## Application by Morgan Offshore Wind Limited and Morecambe Offshore Windfarm Limited for the Morgan and Morecambe Offshore Wind Farms Transmission Assets

### The Examining Authority's written questions and requests for information (ExQ1)

**Issued on 17 June 2025**

Drawing Title:
 Tree and Hedgerow Protection Plan

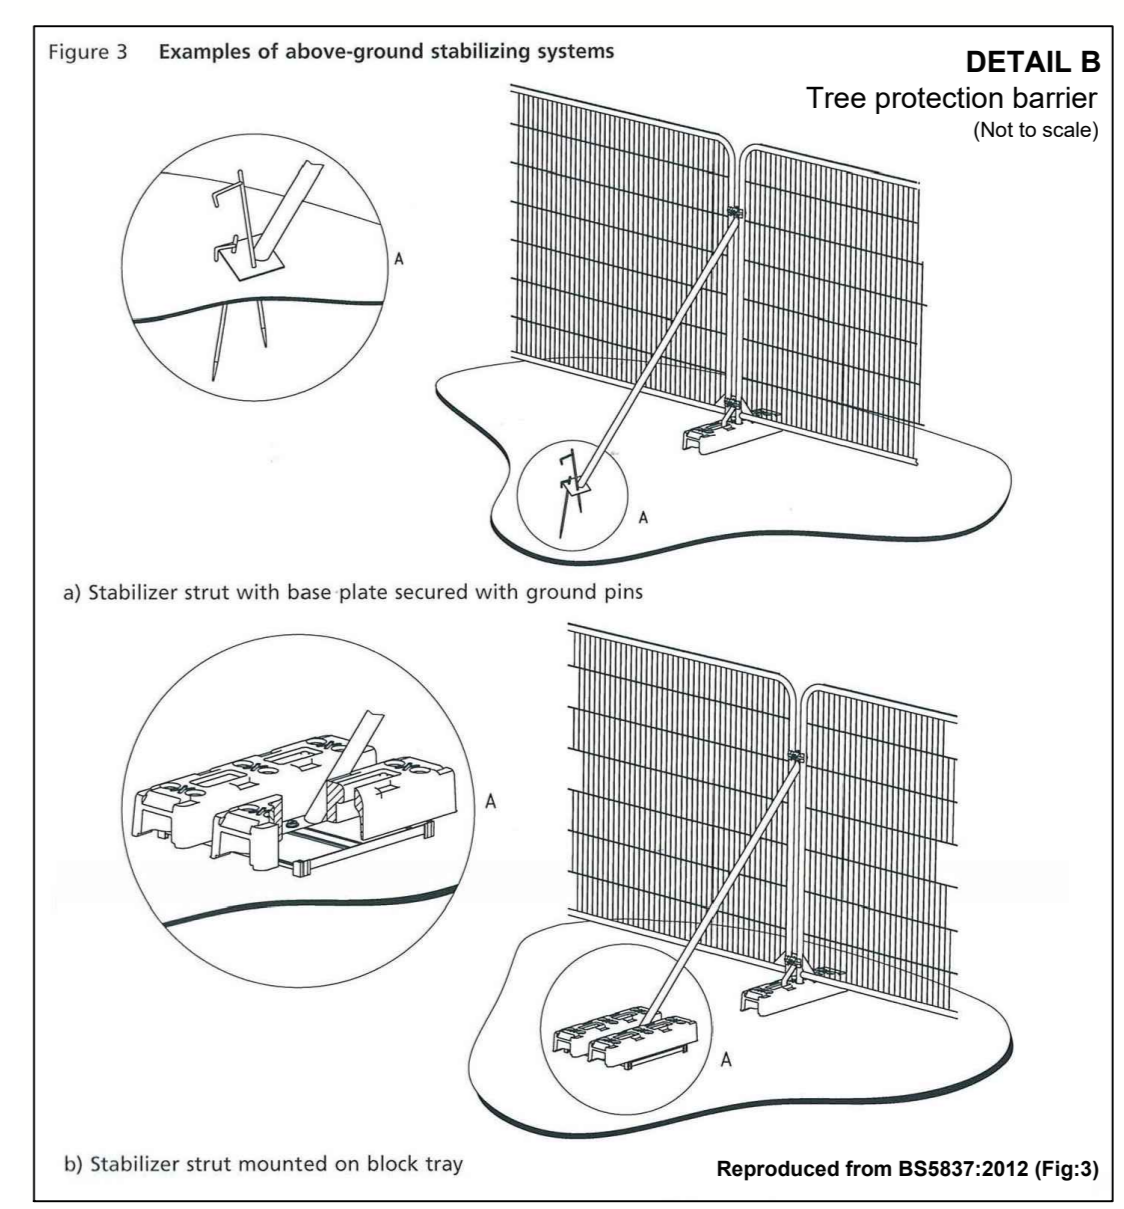
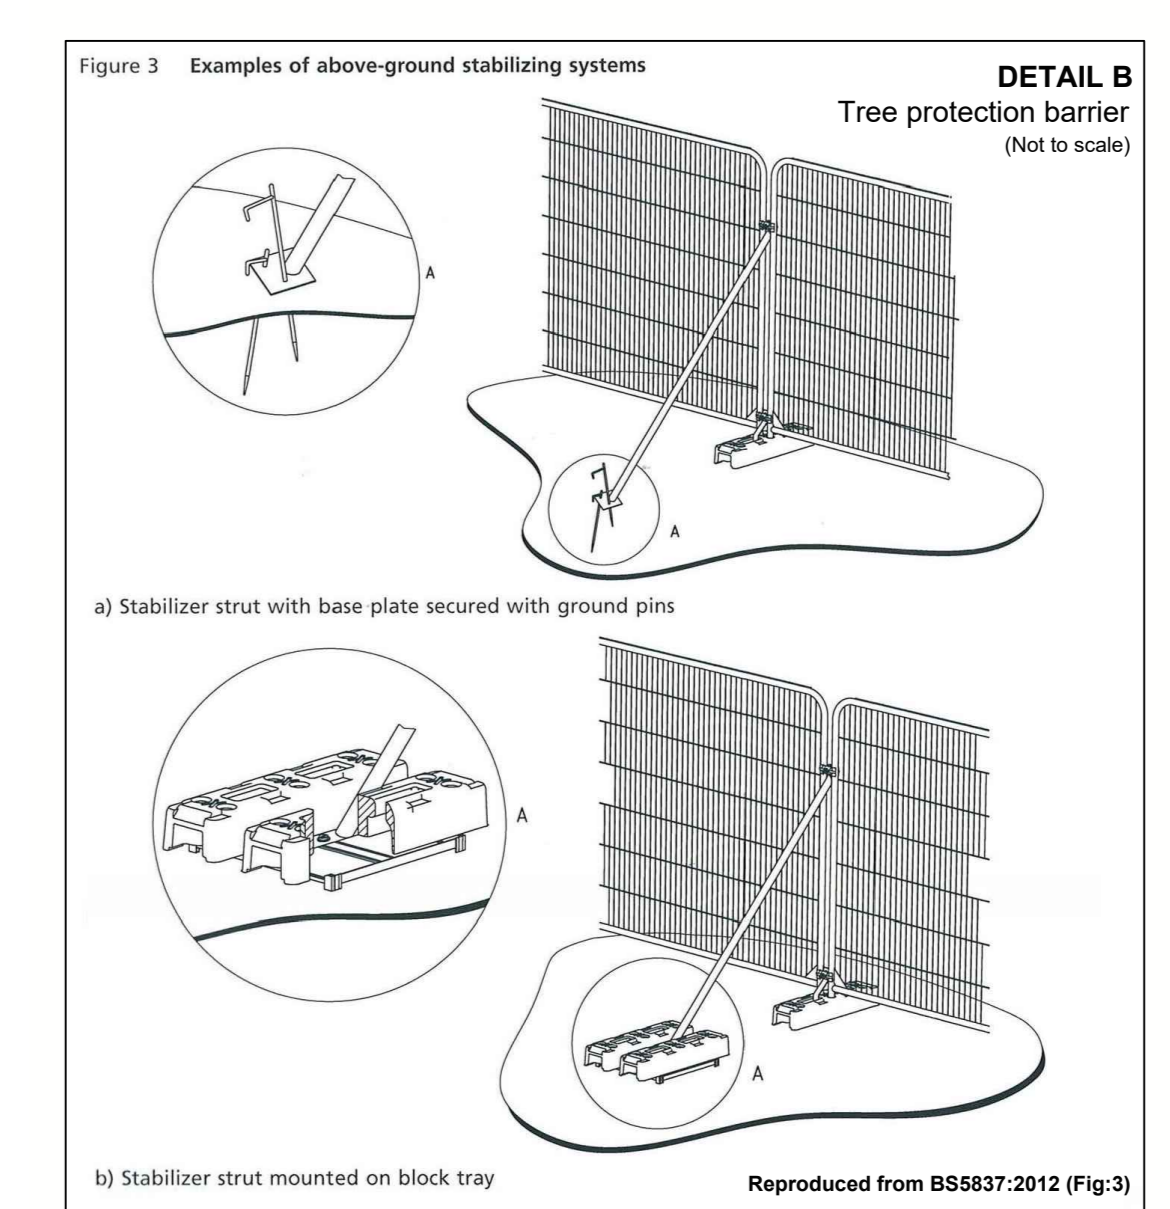
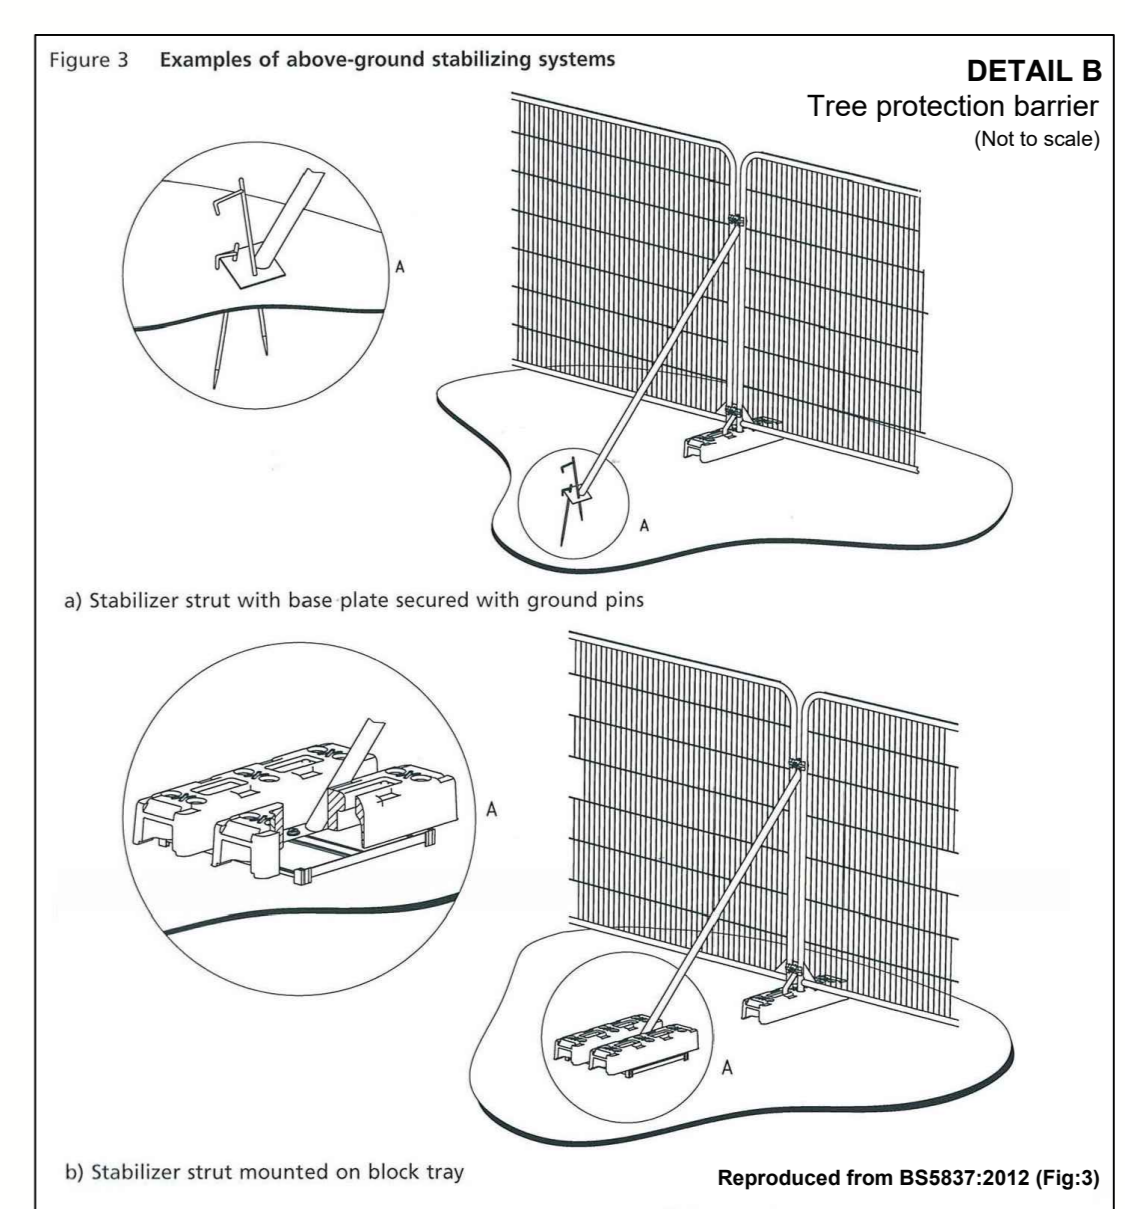
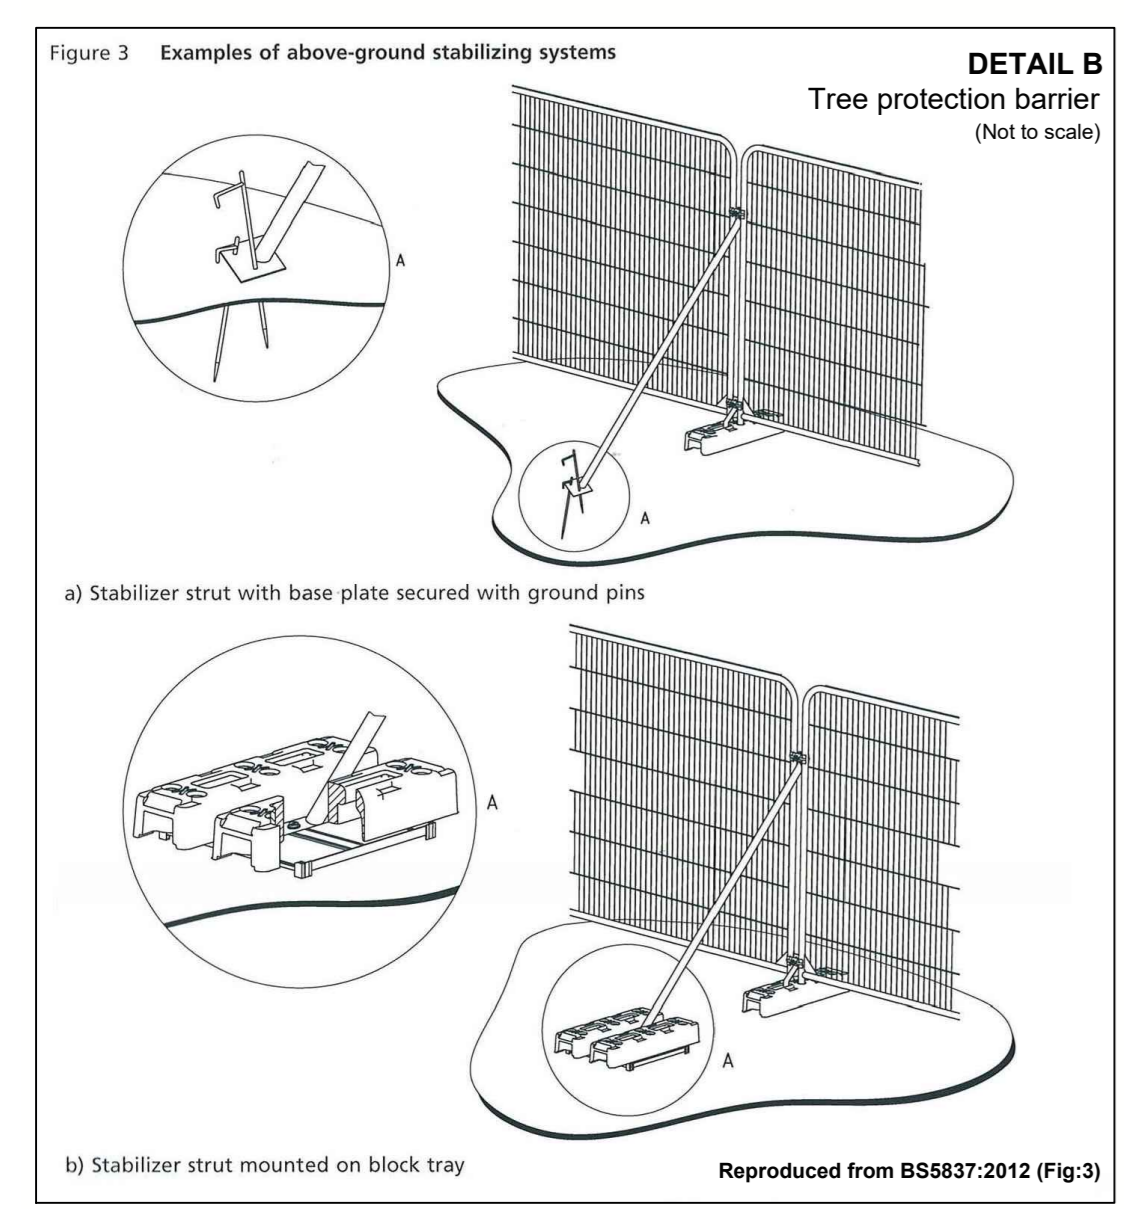
Q2.1.17	The applicants, FBC, SRBC, PCC, LCC	<p><b>Article 36 (Trees subject to tree preservation orders (TPO))</b></p> <p>Paragraph 1.10.1.2 of the Tree survey and arboricultural impact assessment – Part 1 of 2 [APP-128] says that at the time of submission, there is currently no impact on TPO trees.</p> <p>Bearing in mind paragraph 22.3 of Advice Note Fifteen: drafting Development Consent Orders, does this remain to be the position? If there are not TPO trees likely to be affected, is this article necessary and, if it is, should there be provision for consent to be required prior to any works to, currently unknown, trees subject to a TPO?</p>
Q2.1.18	The applicants	<p><b>Article 45 (Requirements, appeals, etc)</b></p> <p>This article refers to Schedule 12 (Approval of matters specified in requirements), including details of the procedure by which appeals can be made. It also includes the application of s.78(1) of the Town and Country Planning Act 1990 where Schedule 12 does not apply.</p> <p>Explain why this is necessary given that all applications for consent, agreement or approval would be covered by Schedule 12 (within which paragraph 7 specifically relates to appeals from decision/ failure to determine).</p>
